BENHALL & STERNFIELD PARISH COUNCIL
MRS MELANIE THURSTON – CILCA CLERK TO THE PARISH COUNCIL

Planning Inspectorate EN010012

Re: The Sizewell C Project

Benhall & Sternfield Parish request for additional measures to be incorporated into the Sizewell C DCO, to mitigate against the currently poor design of the Two Village Bypass (TVB) and the effect that it will have on the dwellings near the A12 and those in the Farnham Hall area.

TWO VILLAGE BYPASS - LONGSECTION 2
SCALE: H 1:2500, V 1:500. DATUM: 0.000

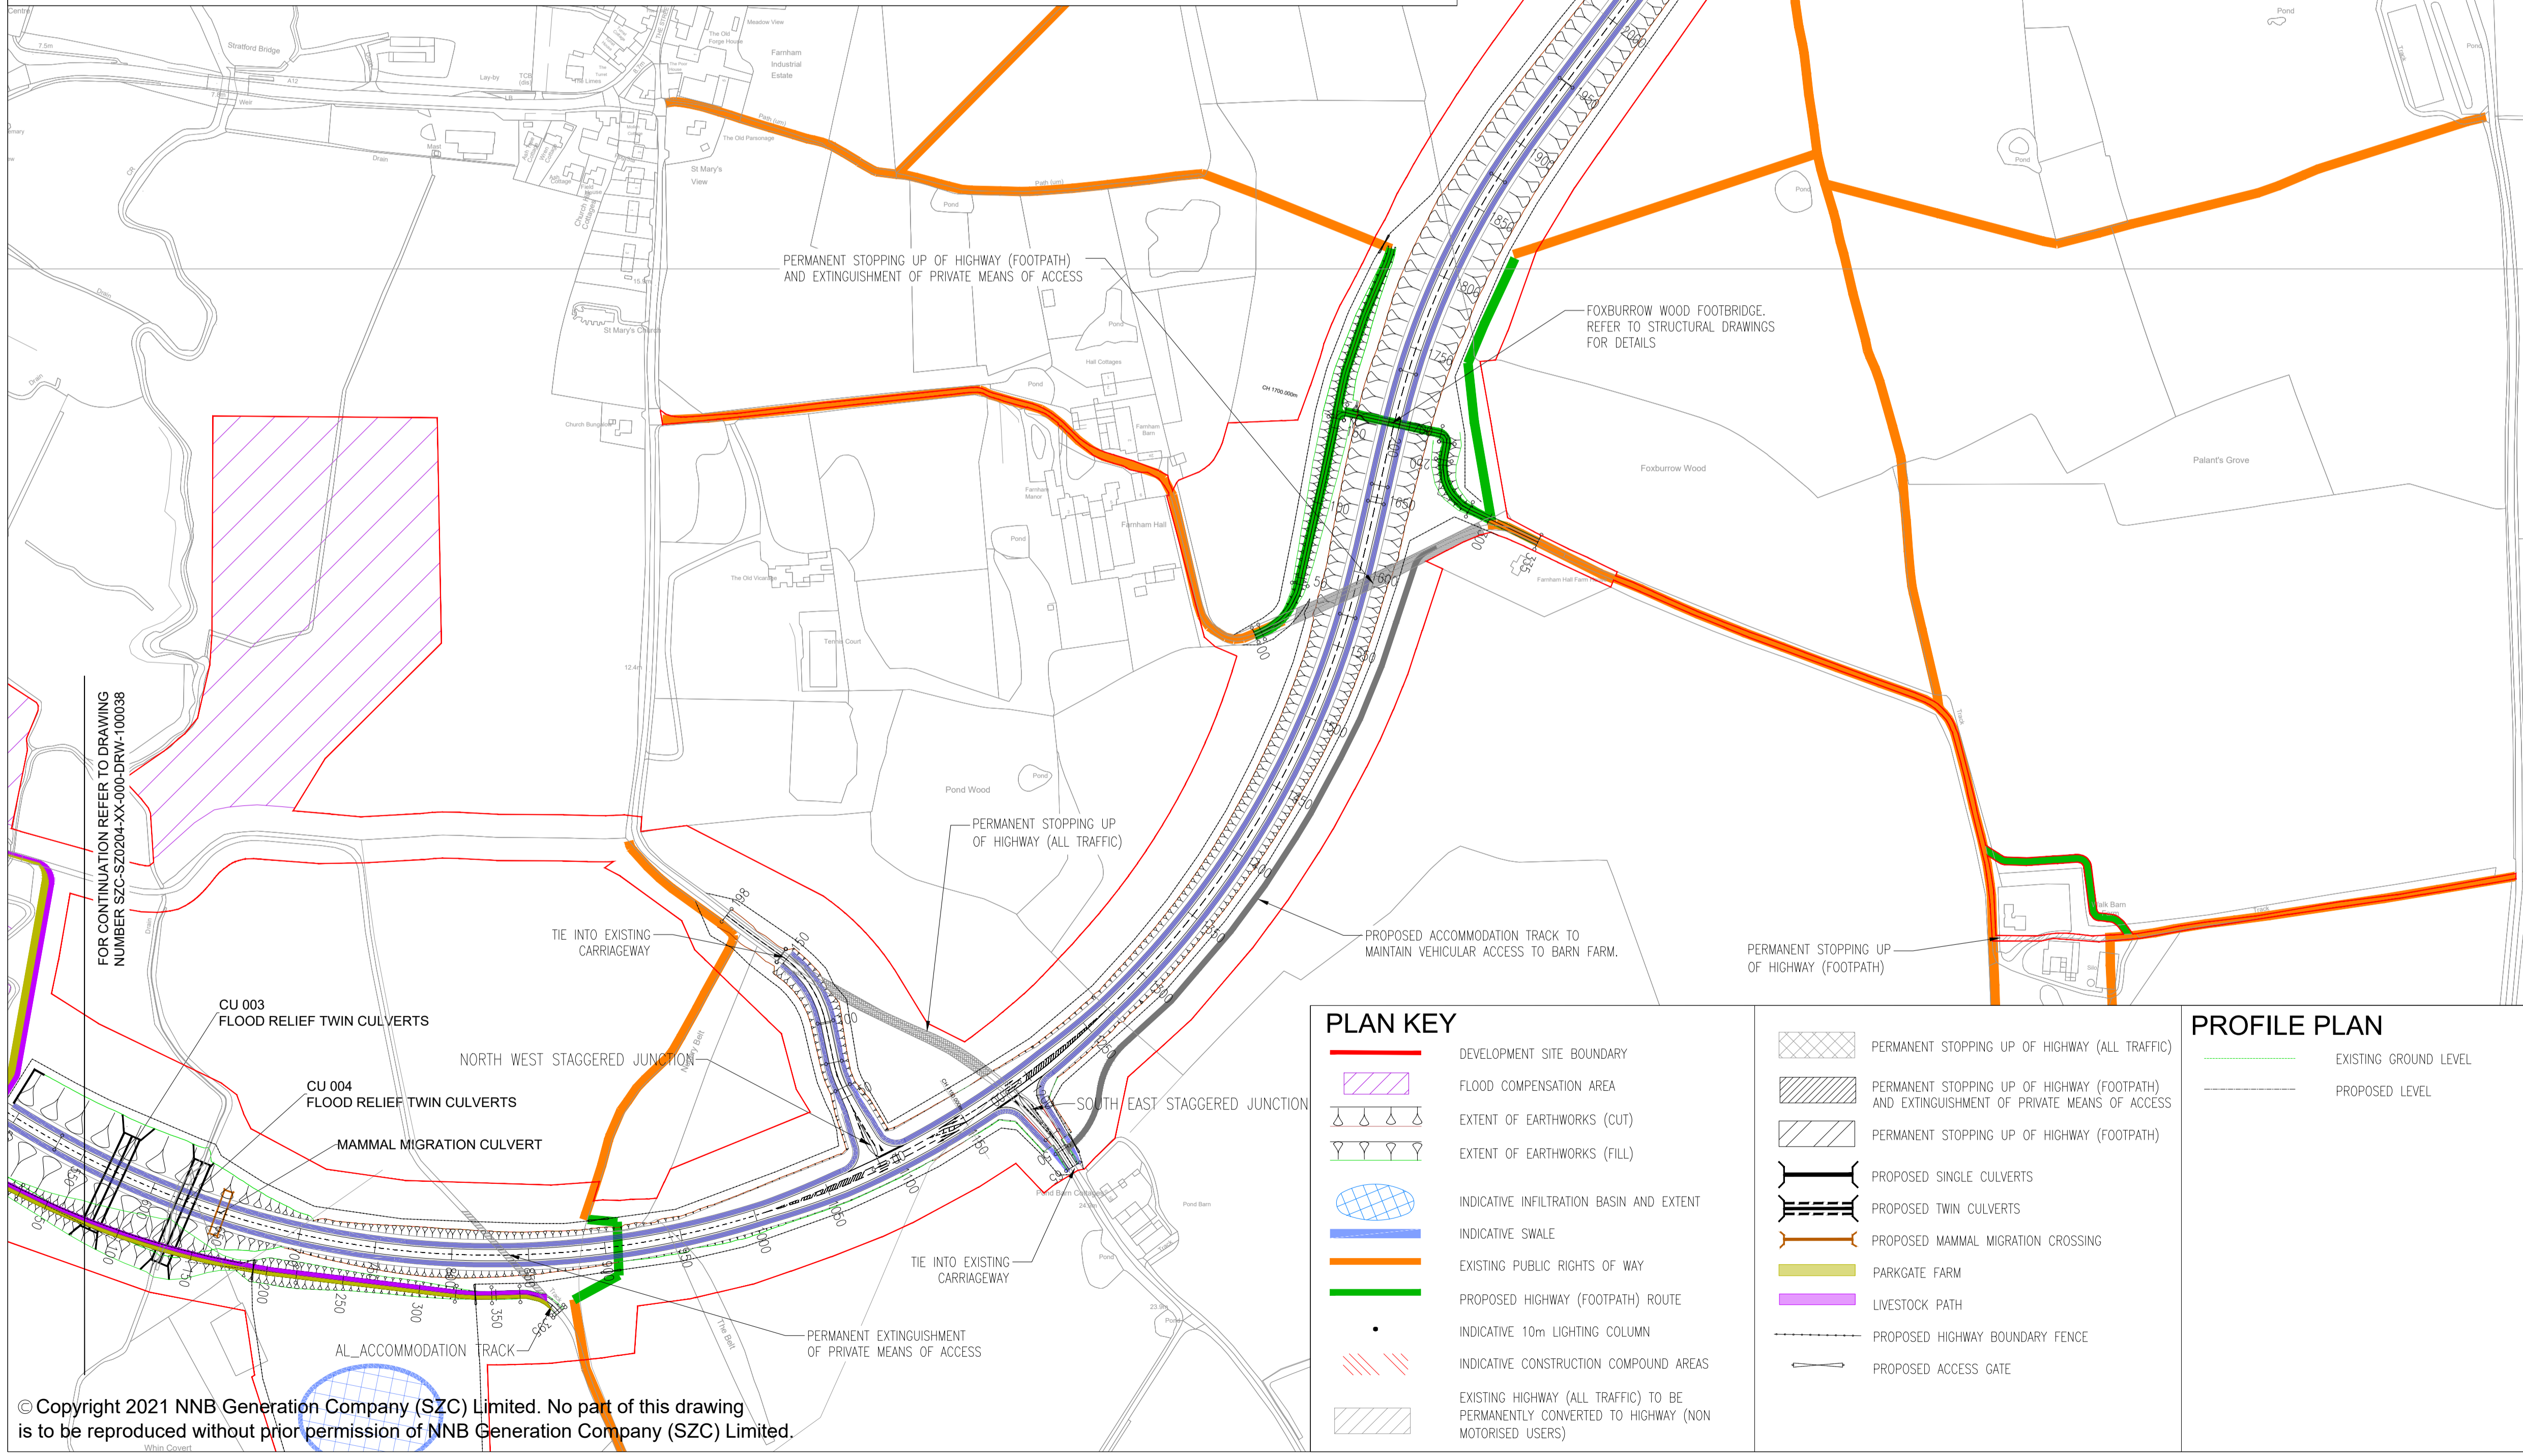
- A bund parallel to the route of the proposed Two Village Bypass to screen business' and parts of property.
- Visual and screening noise attenuation fencing around the eastern construction compound.
- Additional soft and hard landscaping to absorb the bypass into its setting.

Aside from the proximity of the TVB to the neighbouring properties and business', the most significant issue faced is the noise that the bypass will create – both during construction and in-life. The temporary construction area abuts Molletts Farm and is immediately adjacent to the two Benhall Stock Cottages and the Old Police House. Since even EDF admits their TVB scheme will cause irreversible harm to the tranquillity of this setting, we are keen to ensure that they take every possible step to minimise those effects.

We therefore ask for a better TVB design that includes noise-mitigating bunding along the western edge of the northern section (between Friday Street and the Farnham Hall area), low-noise road surfacing in the same zone and safe pedestrian crossings for all four arms of the Friday Street roundabout. We believe that, taken together, these measures will be of significant benefit to all those concerned – which amounts to 17 residential dwellings, Molletts Farm - tourism-led business (which hosts over 1,000 guests a year and contributes to the local economy) and those that live and enjoy walking around the local area.
